Council Reference: DA09/0701.03 LN35979
Your Reference:

Development Application DA09/0701.03 - amendment to Development Consent DA09/0701 for a 251 lot residential subdivision (Department of Planning Application MP09_0166 MOD 3) at Lot 1 DP 169490, Lot 1 DP 175235, Lot 1 DP 304649, Lot 1 DP 781687, Lot 1 DP 781697, and Lots 40 & 43 DP 254416: No. 37 Fraser Drive TERRANORA; Lot 2 DP 778727: Parkes Lane TERRANORA

I refer to your email of 6 August 2019 in which you notify Tweed Shire Council of the Proponents' Response to Submissions regarding the subject Modification.

[illegible]

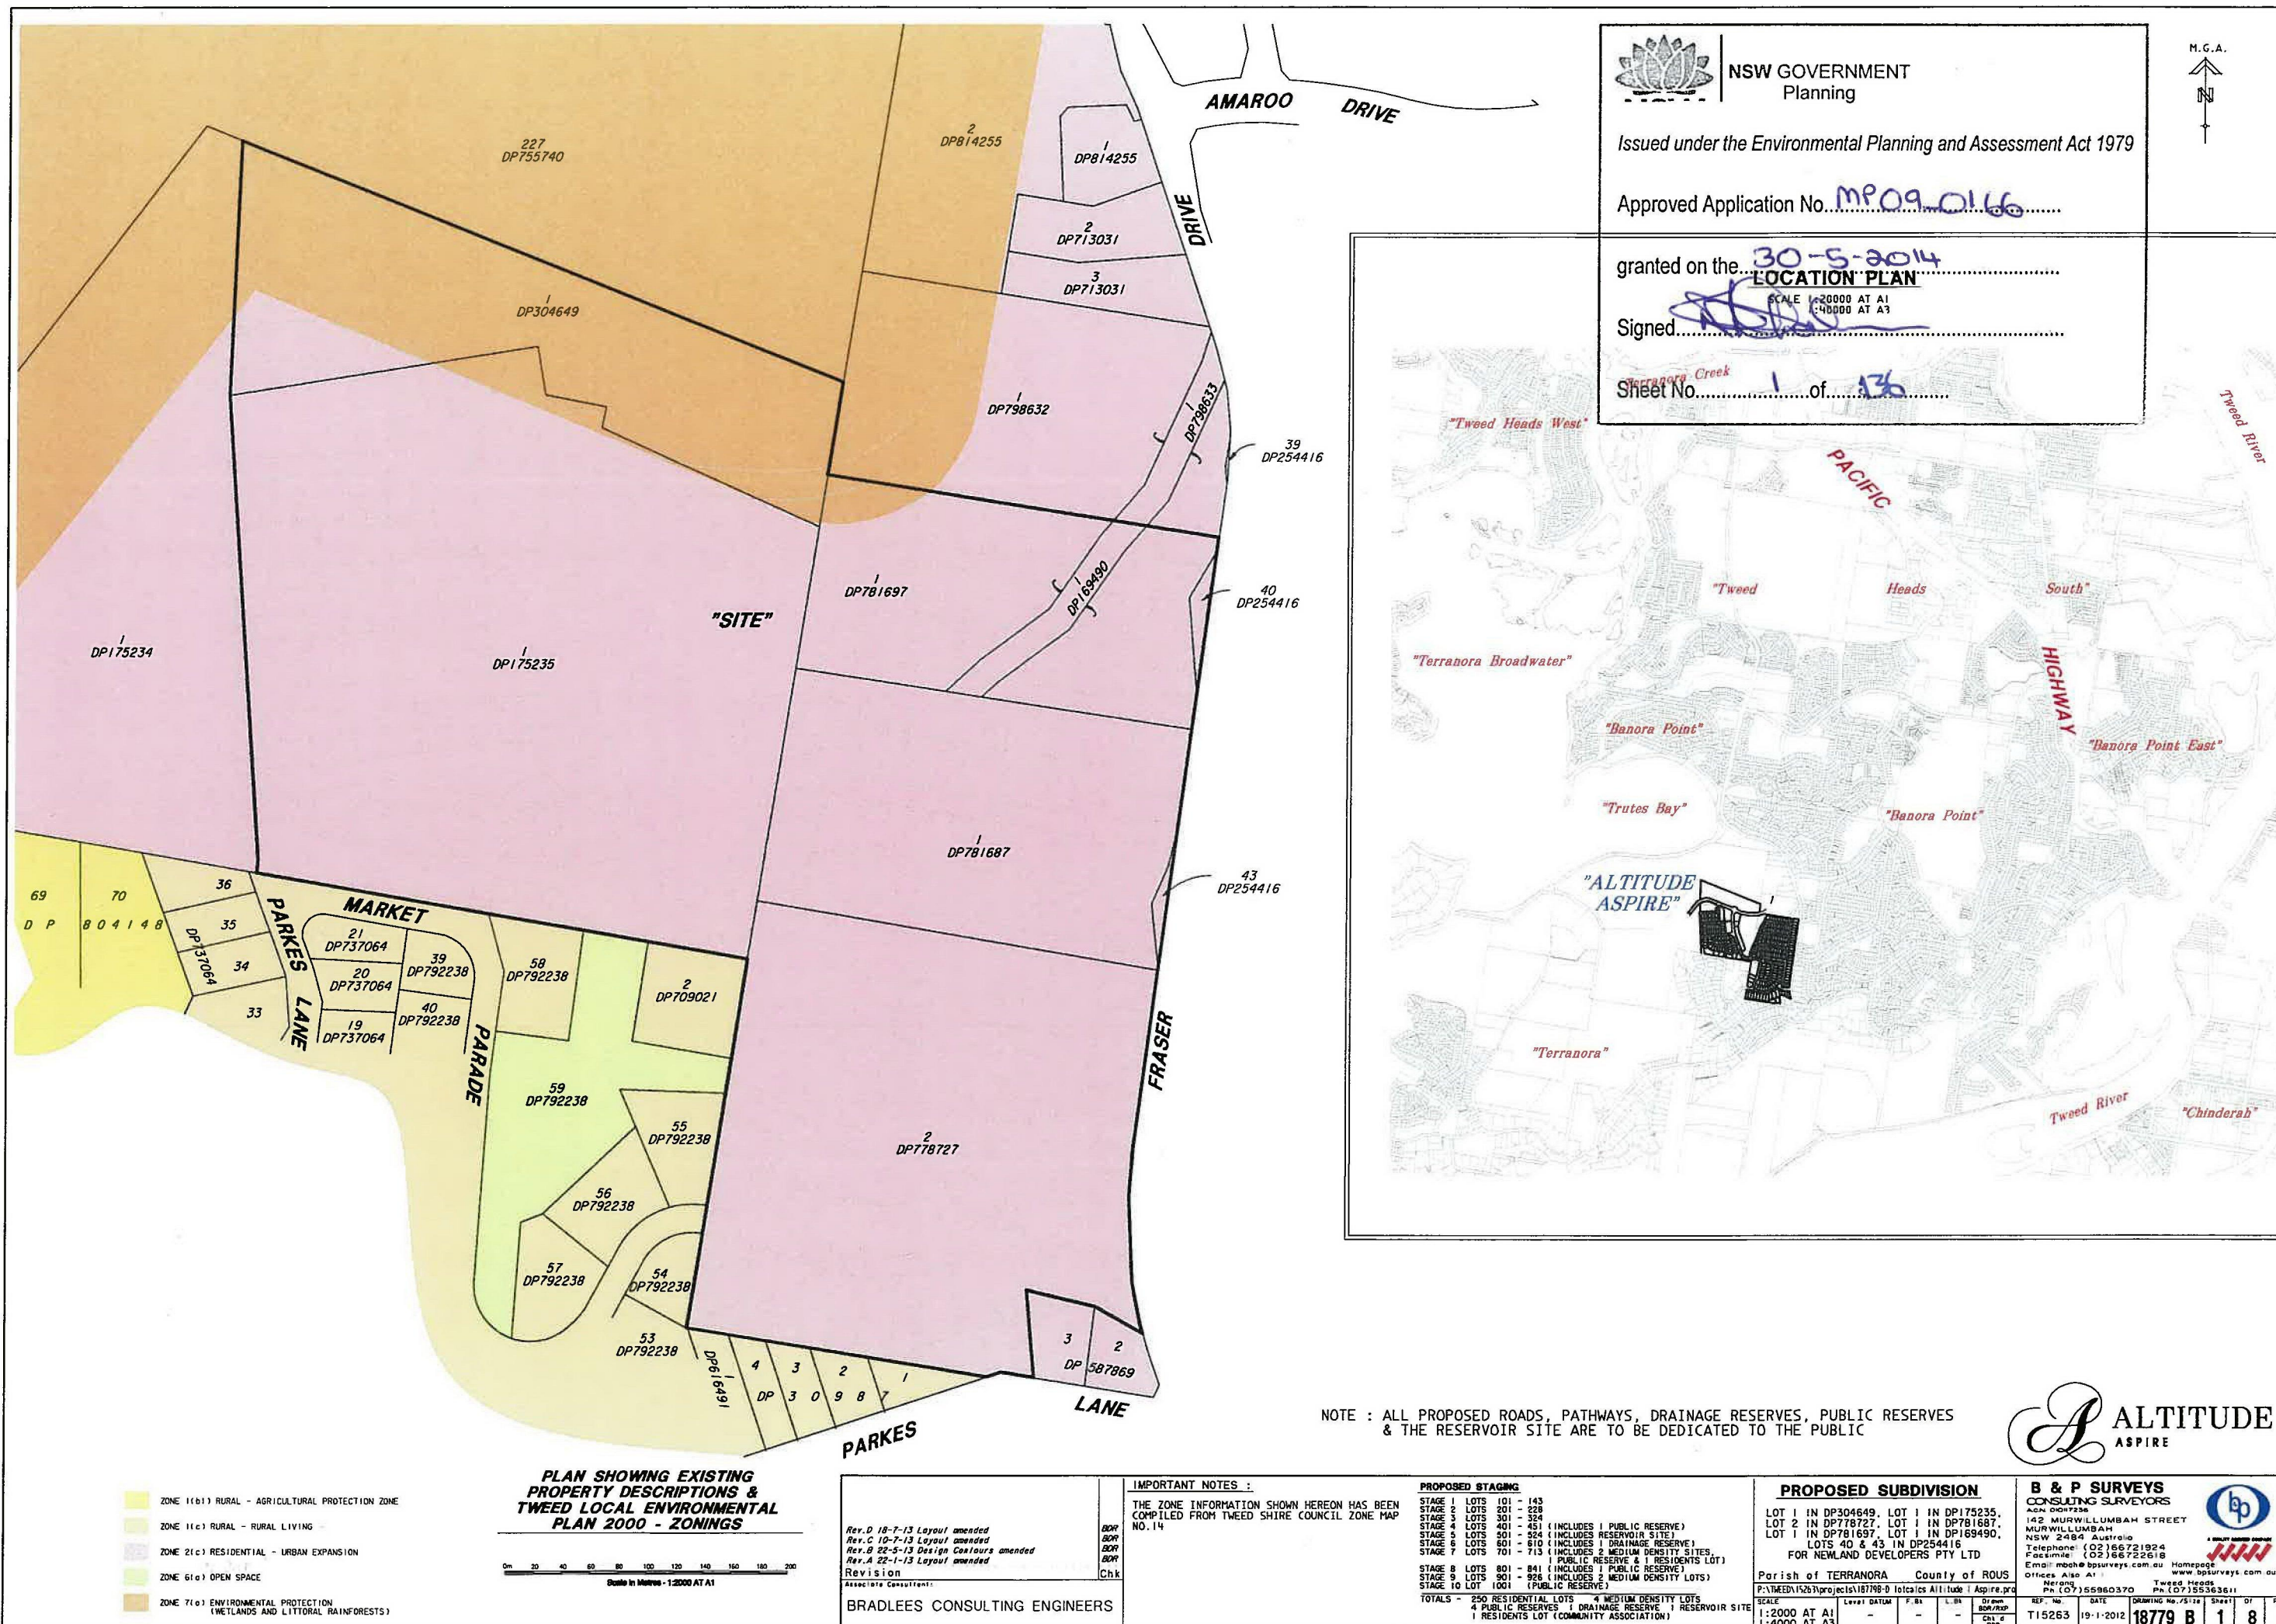
- SK 3608 is the longitudinal section for Road 9, and has been satisfactorily amended to accord with DA Condition B10, however no other associated plans have been changed to reflect Road 9 becoming a cul-de-sac – eg: the separate list of 'Local Office Architecture' plans; engineering plans for 'Road Hierarchy', stormwater, sewer and water provisioning.
- While the Surveyor's subdivision layout plans have been amended to reflect this road change, the supporting engineering drawings were not correspondingly changed. This occurred as part of MOD #2 so will not be further pursued (now).
- It is not considered necessary to amend all other engineering drawings that show Road 9 as a 'through road', provided Condition B10 is retained.

Condition B10 (changing Road 9 to a cul-de-sac): Council withdraws its prior recommendation and support for deletion of this condition, as per comments under Condition A3. This Condition needs to be retained to explain the differences between the Surveyor's subdivision layout plans and the inconsistently amended engineering drawings, relative to Road 9.

Please retain this condition.
